Historic England

**COMMENTS ON MATTERS REQUIRED
FOR DEADLINE 6
(19th May 2020)**

A1 Birtley to Coal House Improvement Scheme, Tyne & Wear

PINS Reference No: TR010031

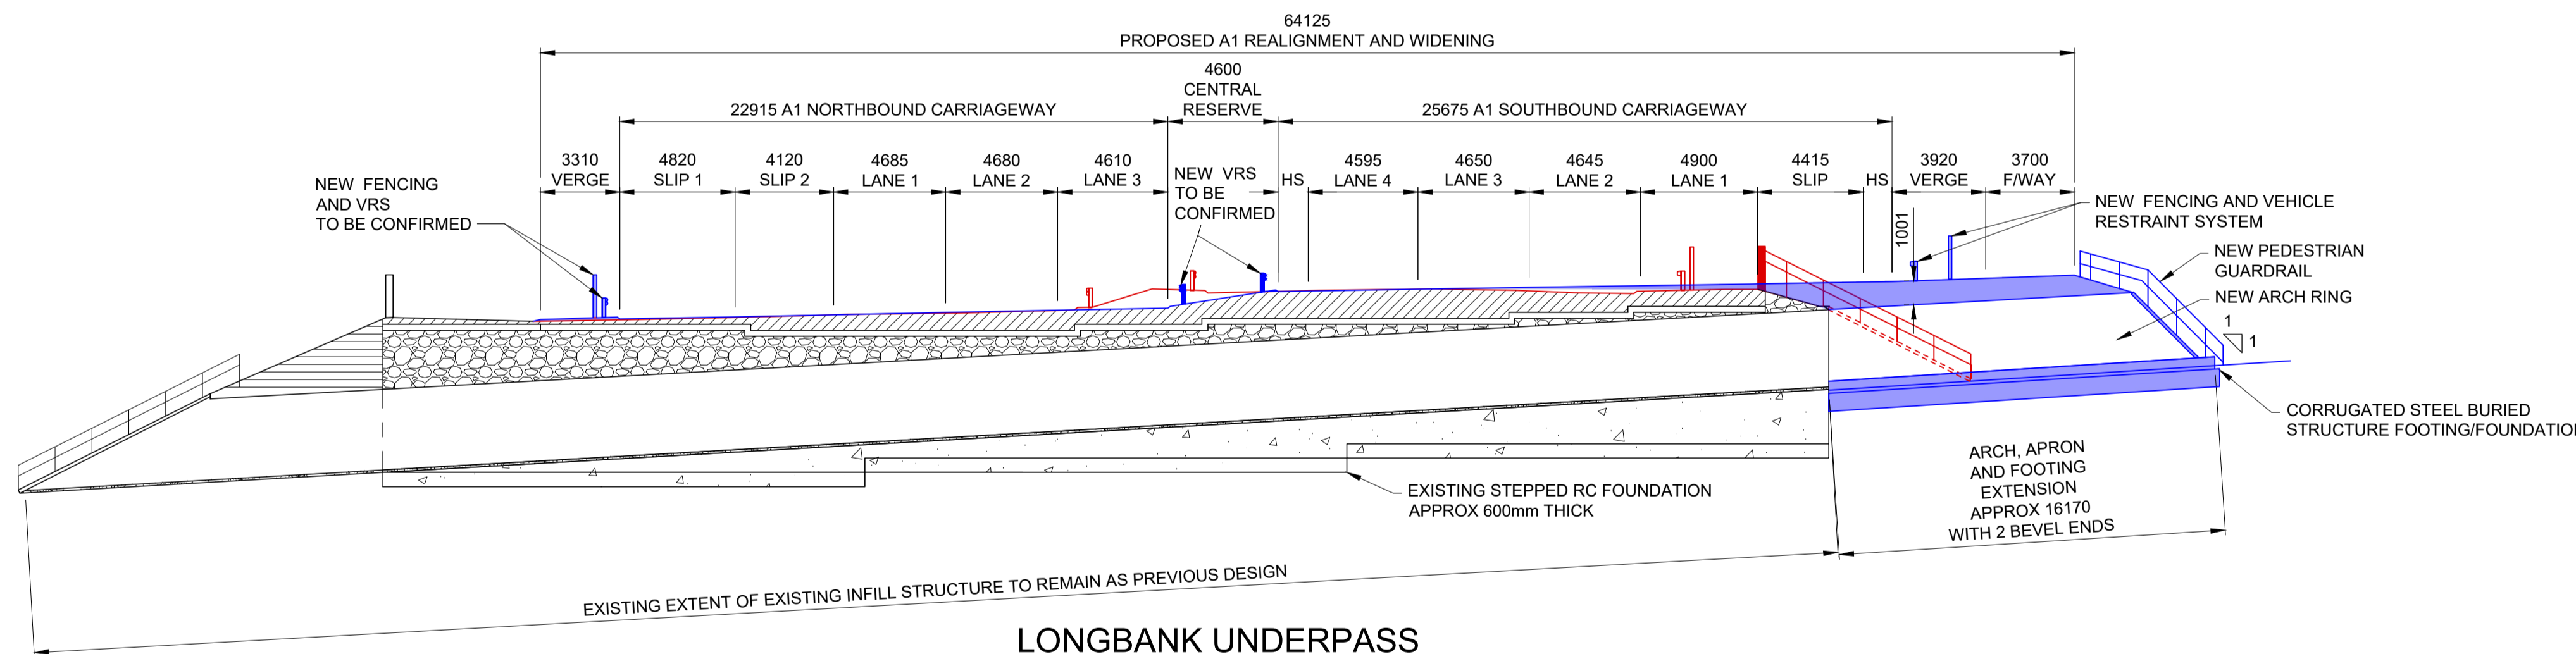
- 3.4 The Applicant's response to this question refers back to "*Structures Engineering Drawings and Sections (Revision 2) TR010031/APP/2.7(J)*" (REP4- 010) as clearly showing the proposed access. However, we do not find this to be the case nor is it fully indicative, for example the location of the access back onto the Monument is not shown on the drawing as the Applicant does not yet have detailed drawings. However, it is our understanding a new CH10 action in the Outline CEMP (see 3.4 above) to be submitted at Deadline 6 will provide some more certainty about the works and we would consider it appropriate that a clearer drawing is included here which also shows the boundary of the scheduled monument. We await the revised Outline CEMP submission at Deadline 6 to see whether this issue has been addressed and will update the Examining Authority accordingly.
